**Submission regarding Global Switch Data Centre (MP 08_0222 MOD 7)
Modification Application under Section 75W of the EP&A Act 1979**

I refer to the Request to Modify a Major Project or Concept Project which is an application made by Ms Helen Mulcahy of Helen Mulcahy Urban Planning Pty Ltd. The request is for the *Modification of the approved construction hours to enable internal works to be carried out within Stage 2 of the approved development. Amend Condition A2 and insert new condition D8.1*

Figure 2 Acoustic context of the approved development (Source: Acoustic Logic)

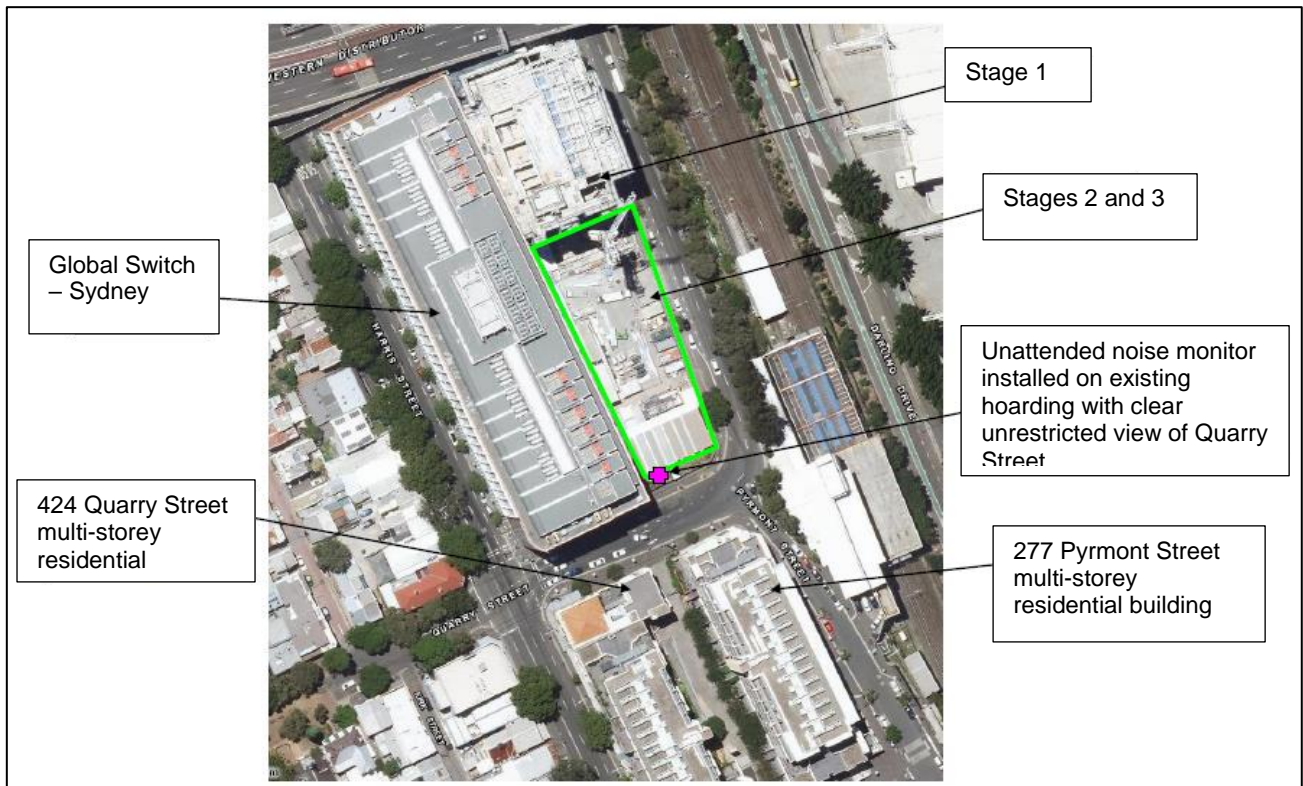
I believe the submission made by Helen Mulcahy¹ incorrectly identifies the multi-storey residential buildings. I refer to an aerial photo on page 9² where the Quarry Building is shown as “424 Quarry Street” and the Pymont Building is shown as “277 Pymont Street”. This aerial photo is attributed to Acoustic Logic.
